Tel: 01903 737756
Email: planning@arun.gov.uk
www.arun.gov.uk/planning
Please ask for: Ms Iqraa Malik
Email: iqraa.malik@terraquest.co.uk
Telephone: 0121 234 1390
Our Ref: BE/2/26/HH
Your Ref:
Date: 15th January 2026

Application for Planning Permission for Works or Extension to a Dwelling

Development: Single storey extension to an existing two bedroom dwelling.
Location: 18 Potters Way North Bersted PO21 5FY

1 Ground Floor Plan (Existing)
Scale: 1:50

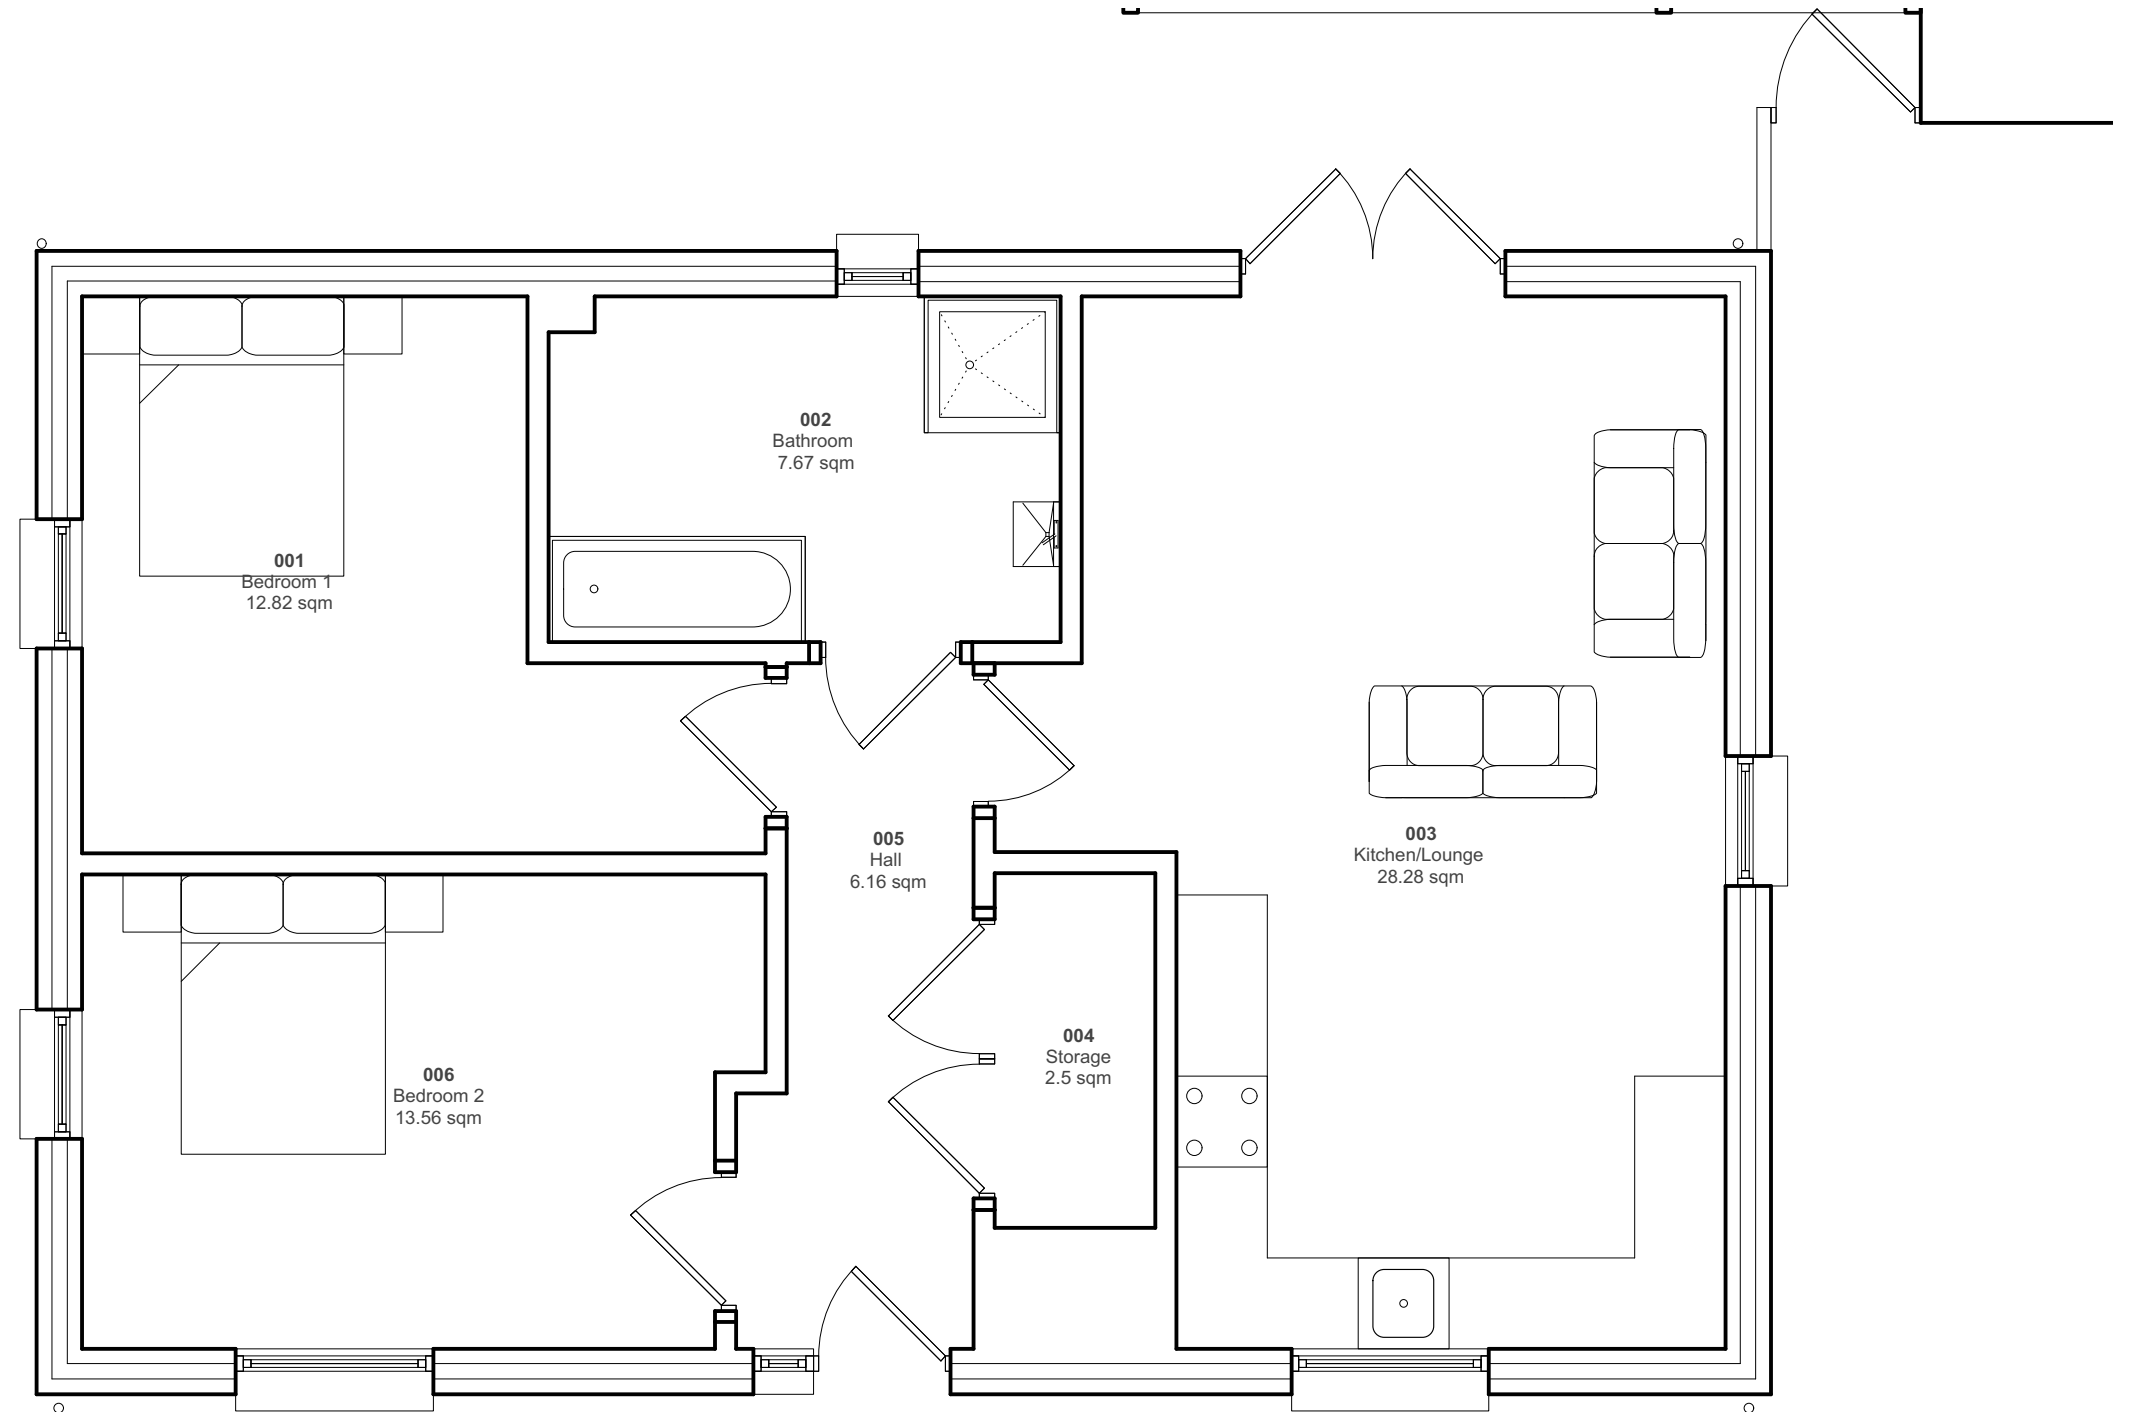
Inconsistent Plans

The windows are inconsistent between the existing floor plan and the existing north elevation, please review and amend.

Scale: 1:200 @ A3
Drg.No. NHA-005-P Rev C
Site Plan (Proposed)

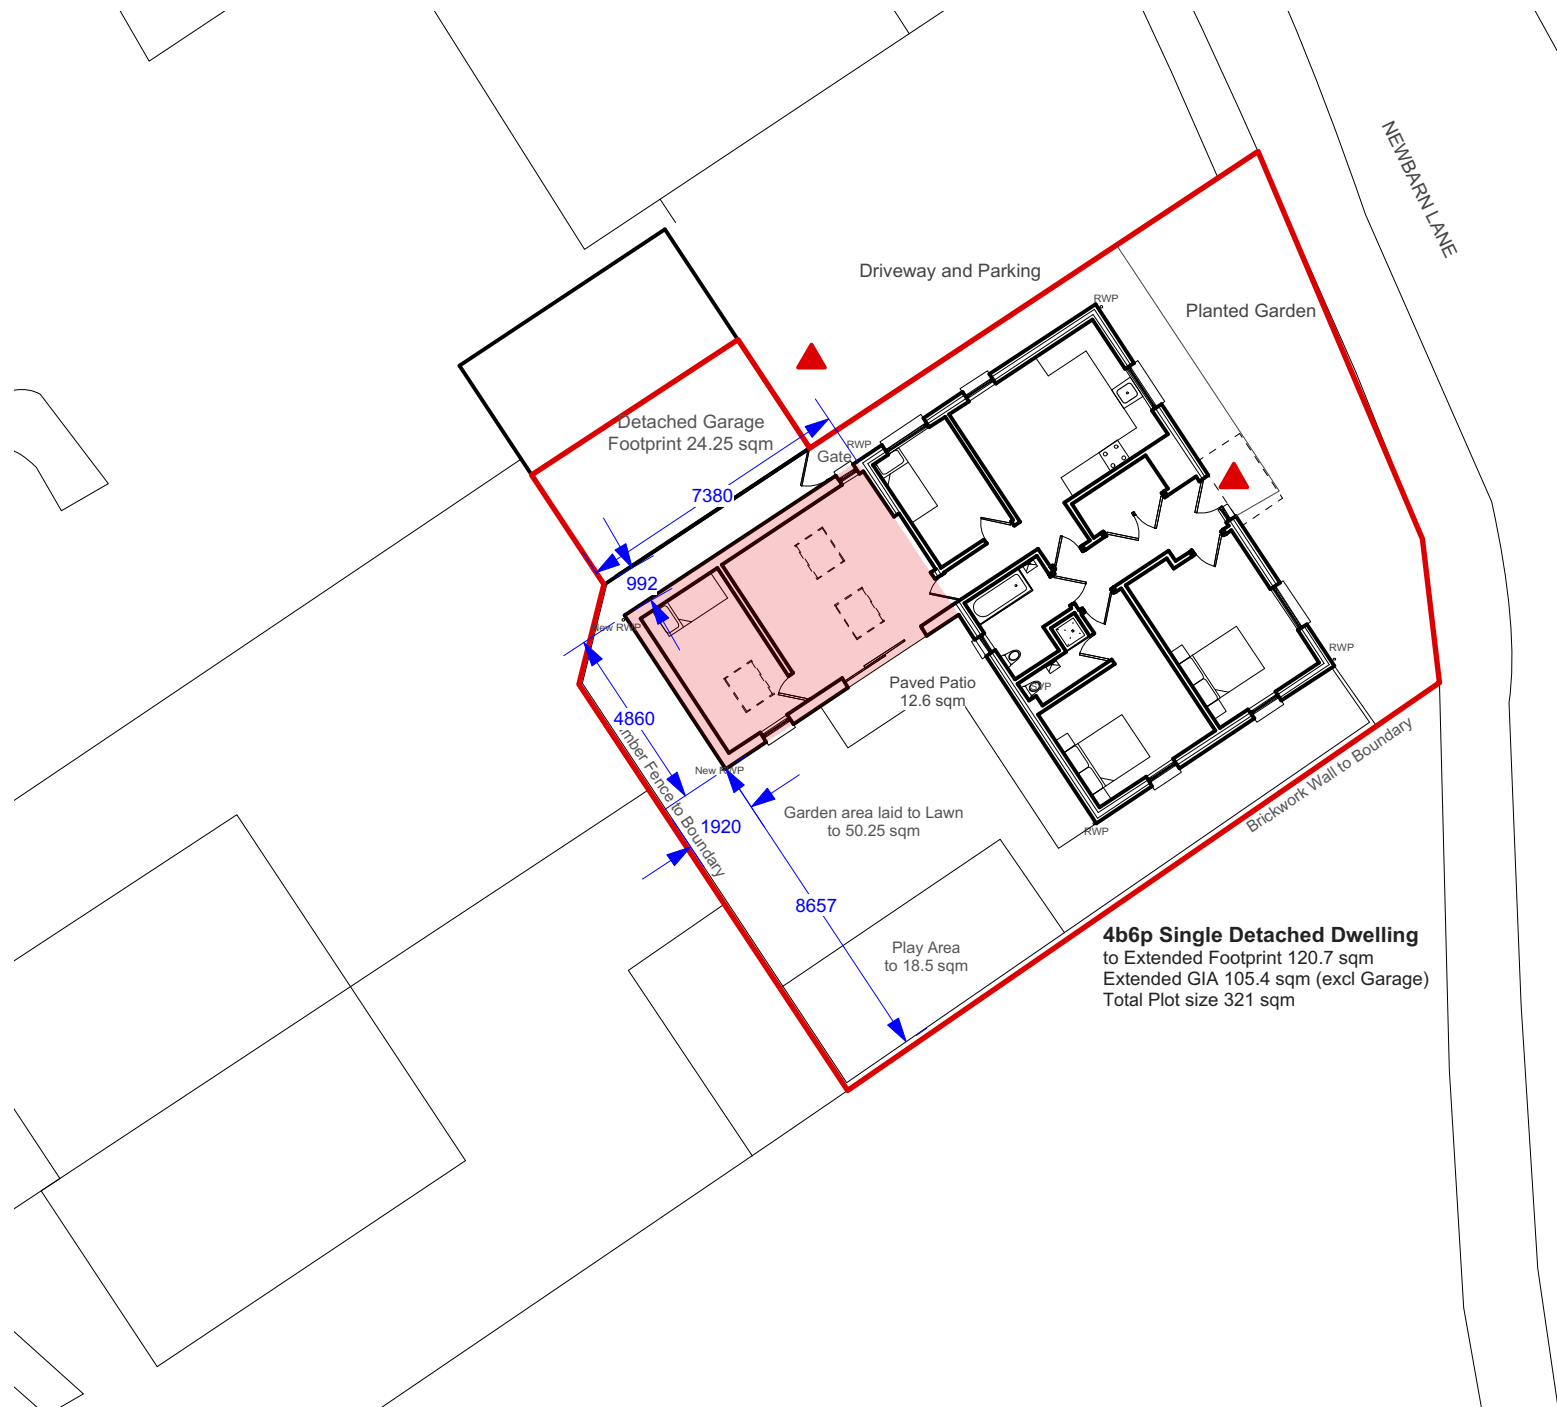
Block Plan

You are required to have dimensions from the proposed extension(s) to all site boundaries. Please amend

1 North Elevation (Proposed)
Scale: 1:100

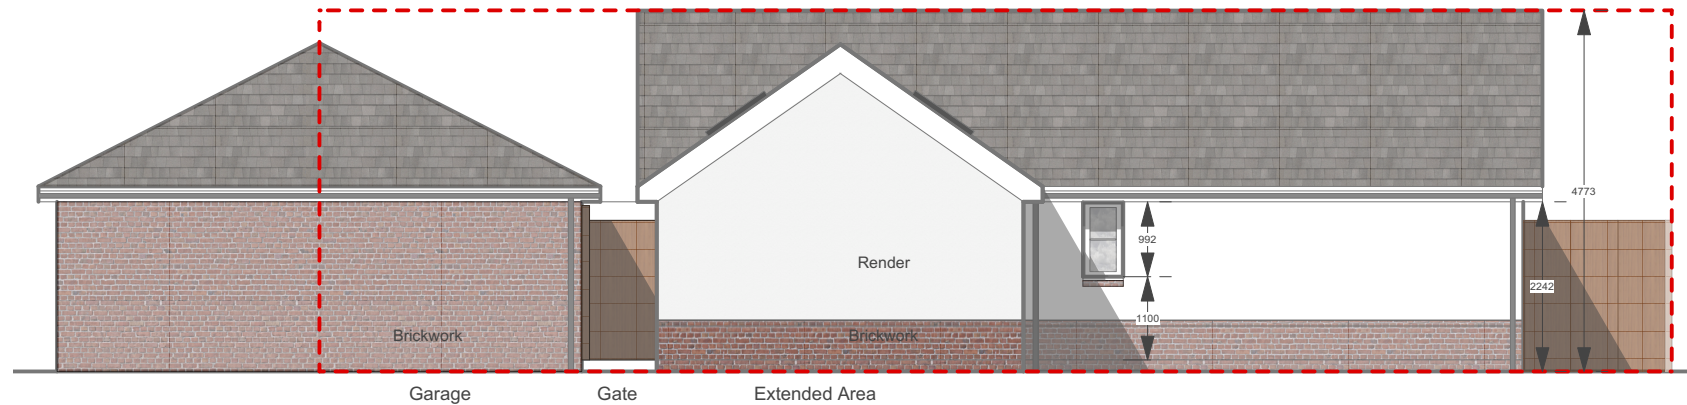
Please submit the proposed north elevation without the garage obstructing the view.
